Reference No: **2024/NM/90797/E**

Site Address: 14, Shirley Mount, Gomersal, Cleckheaton, BD19 4NL

Description: Non material amendment to previous permission
2020/91183 for erection of two storey and single
storey rear extension and external alterations

DECISION – Non-Material Amendment Approved

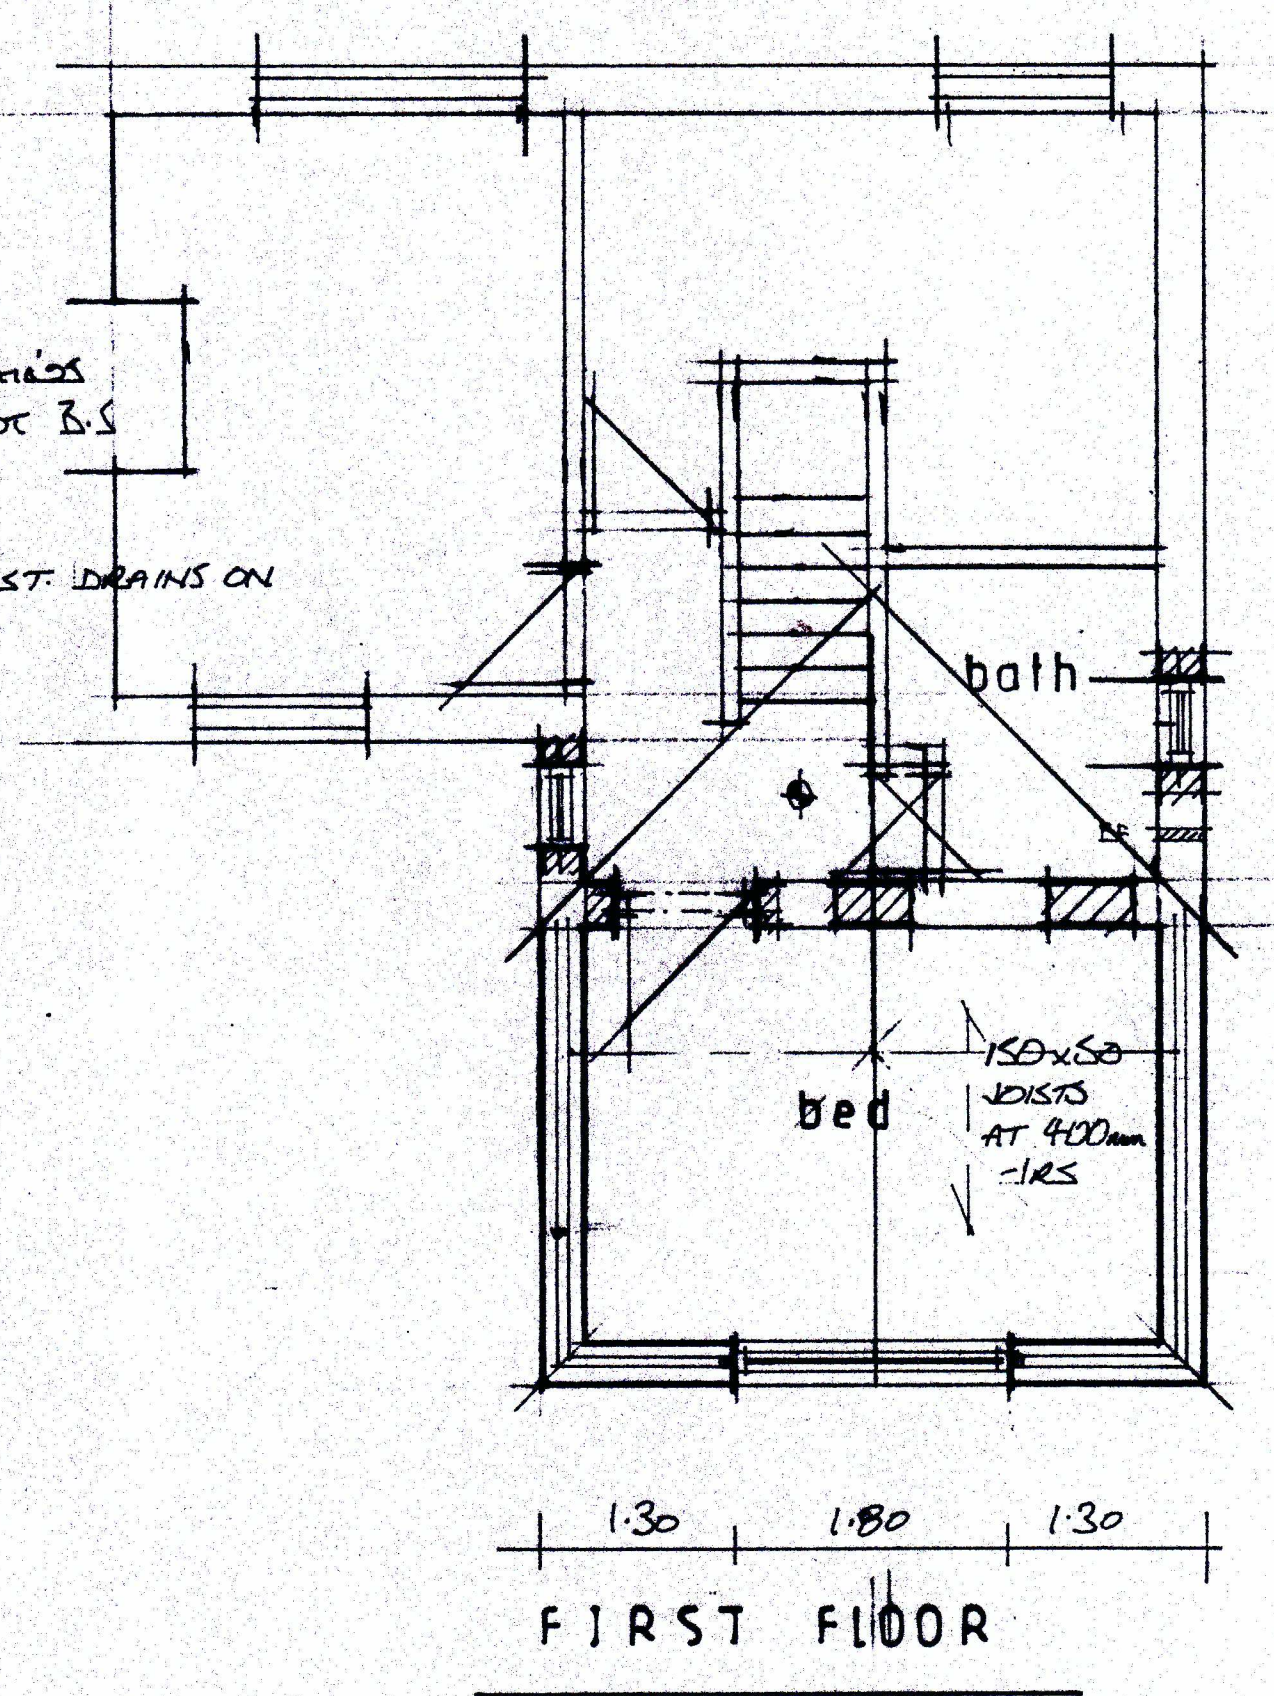
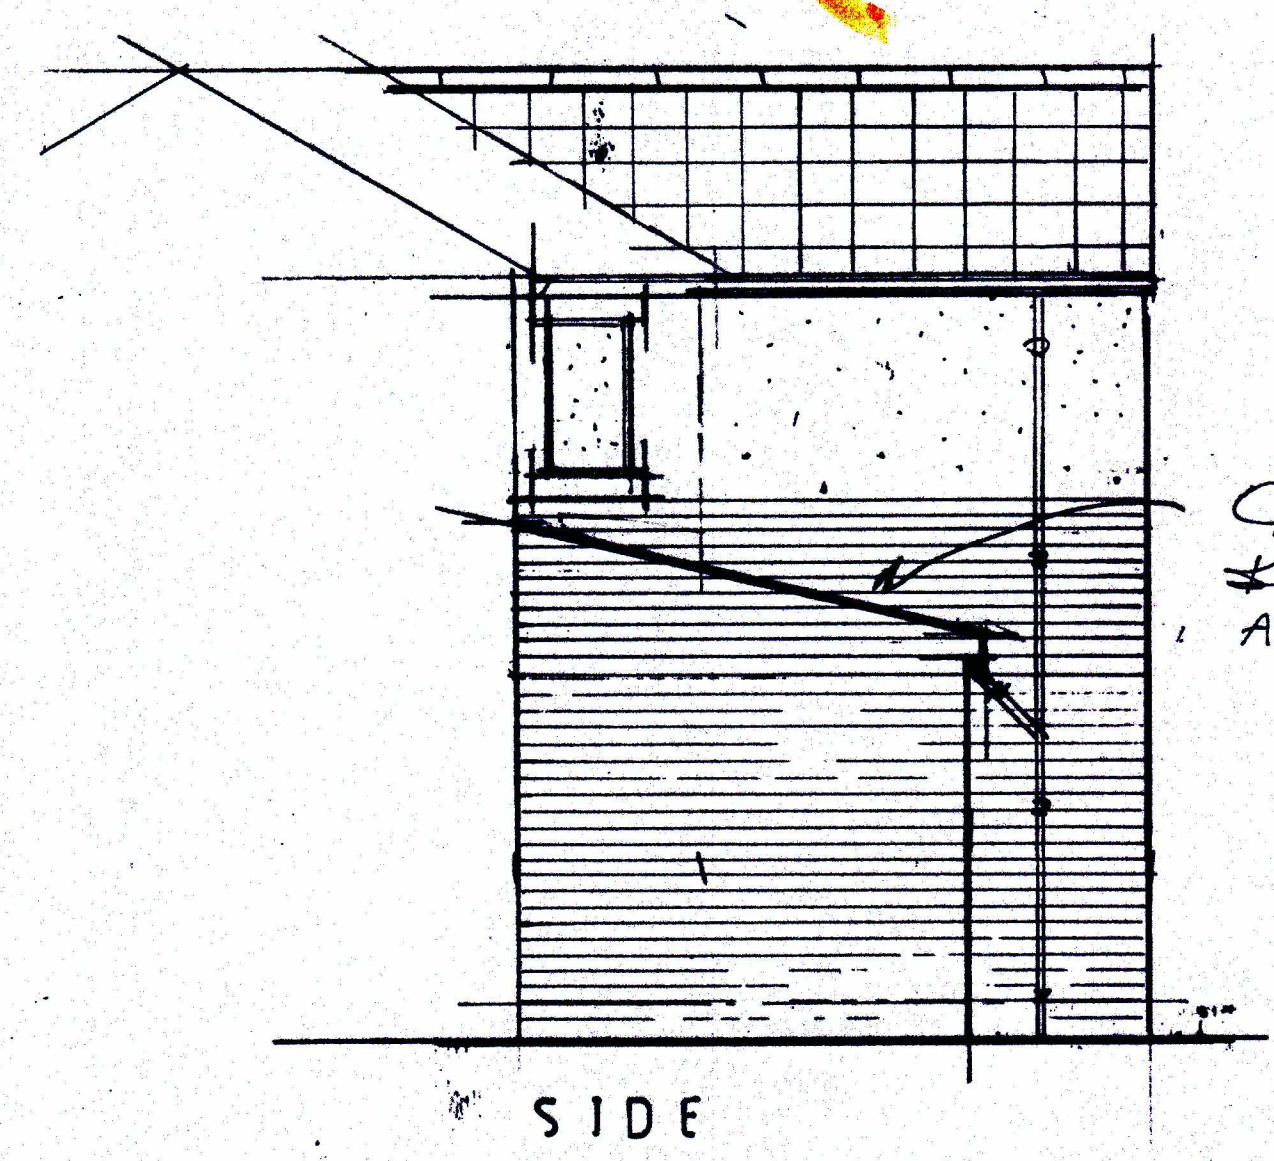
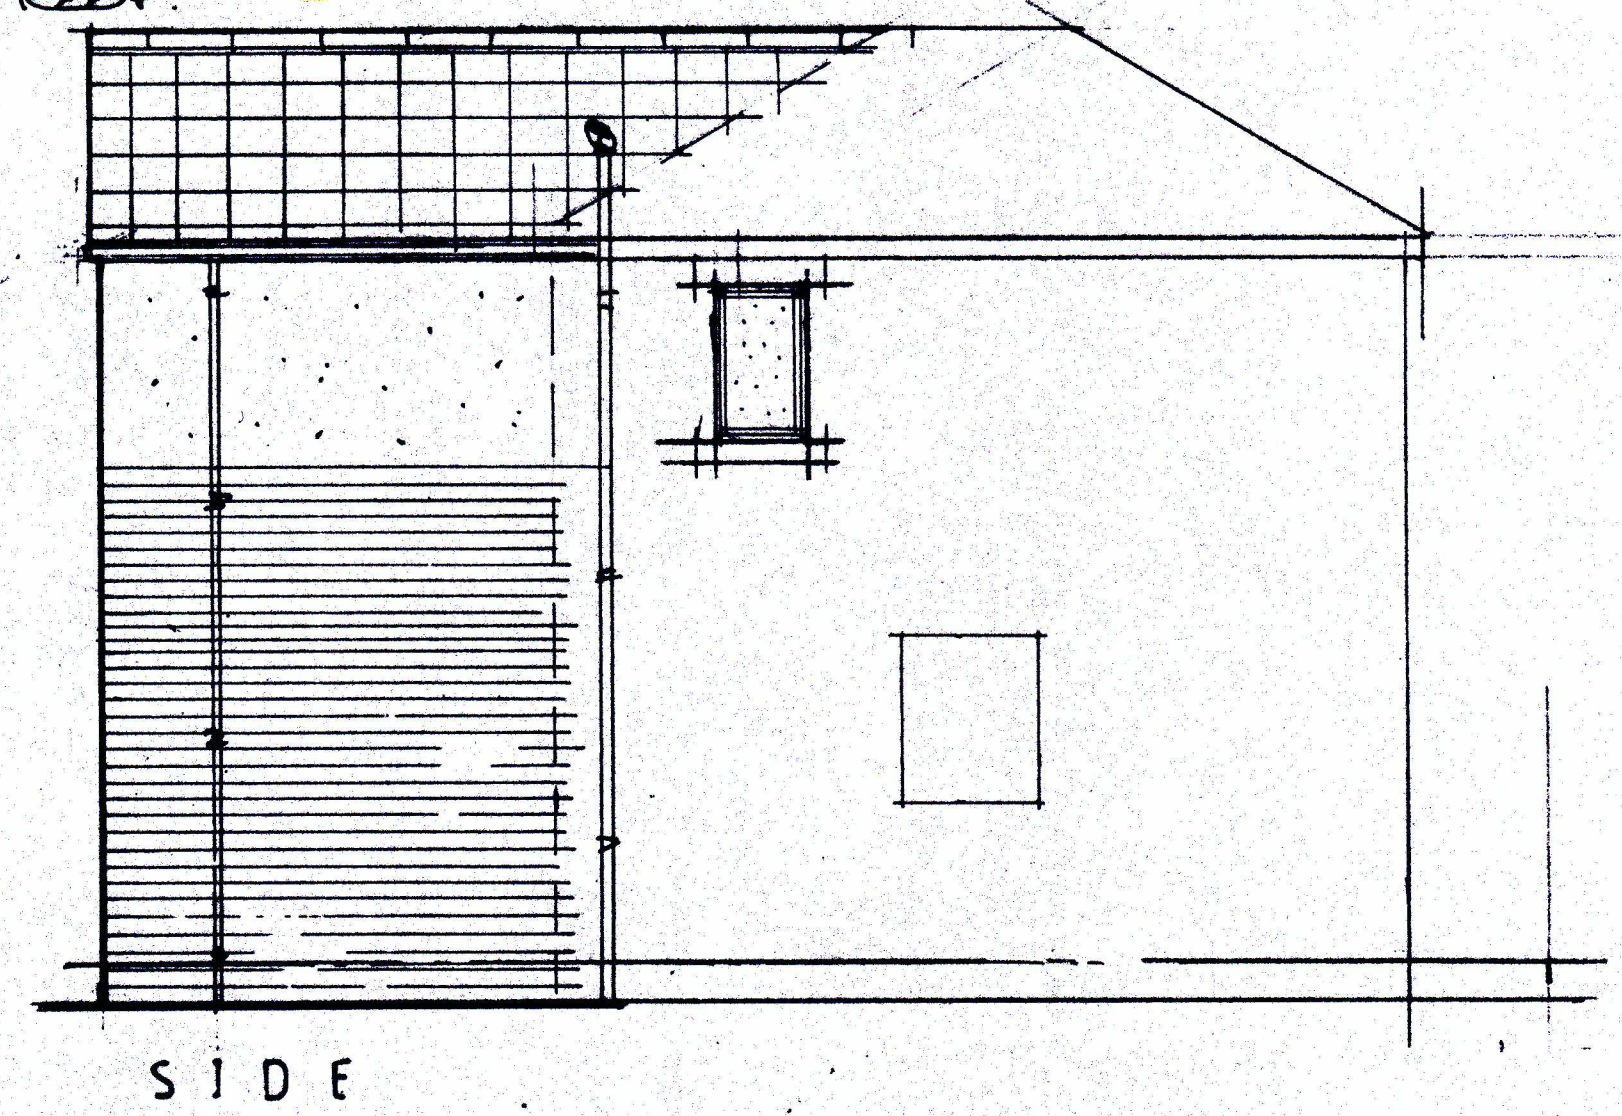
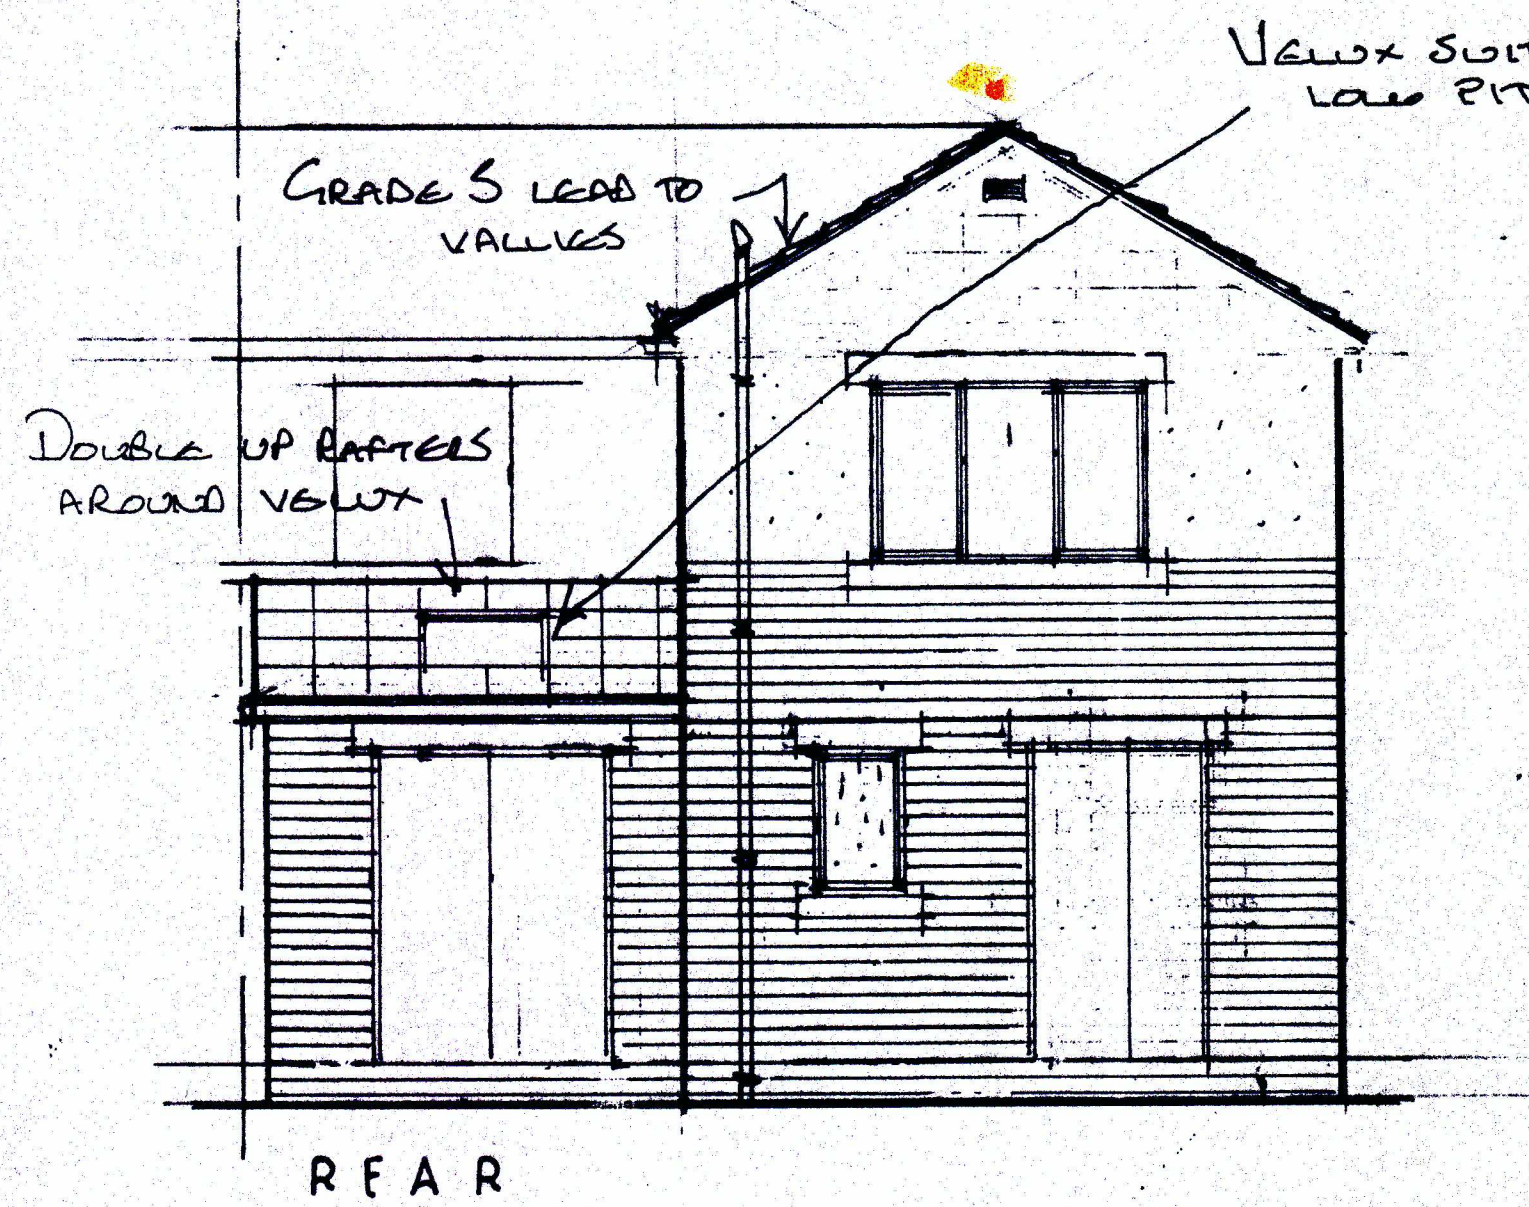
The amendment seeks to change the roof style on the two-storey section of the building from a hipped roof to a gable-end roof.

In terms of character, the development relates to a rear extension which is not visible from the public domain. Original roof types in the area are predominately hipped, including a rear extension of a nearby property. However, given the modest alteration, which is at the rear of the building, it would not be to the detriment of the character of the host dwelling or the character of the area.

In terms of impact to living conditions, the roof will be ~1.50m from the adjoining semi-detached building. Given the distance, there will not be a loss of outlook or a loss of light from the change to the roof shape. In terms of 13 Shirley Mount, there may be a minor reduction in sunlight observed in parts of the residential garden during the winter months when the sun is low, however the loss of sunlight is considered to be

minimal. Again, due to distance there will not be a loss of light in habitable rooms or outlook.

The alteration of a hipped roof to a gable-end roof would neither impact the character of the host dwelling or wider area, nor have an impact on the living conditions of neighbours.

On the basis of the above, the proposed change would be acceptable under the non-material amendment procedure and as such is recommended for approval.
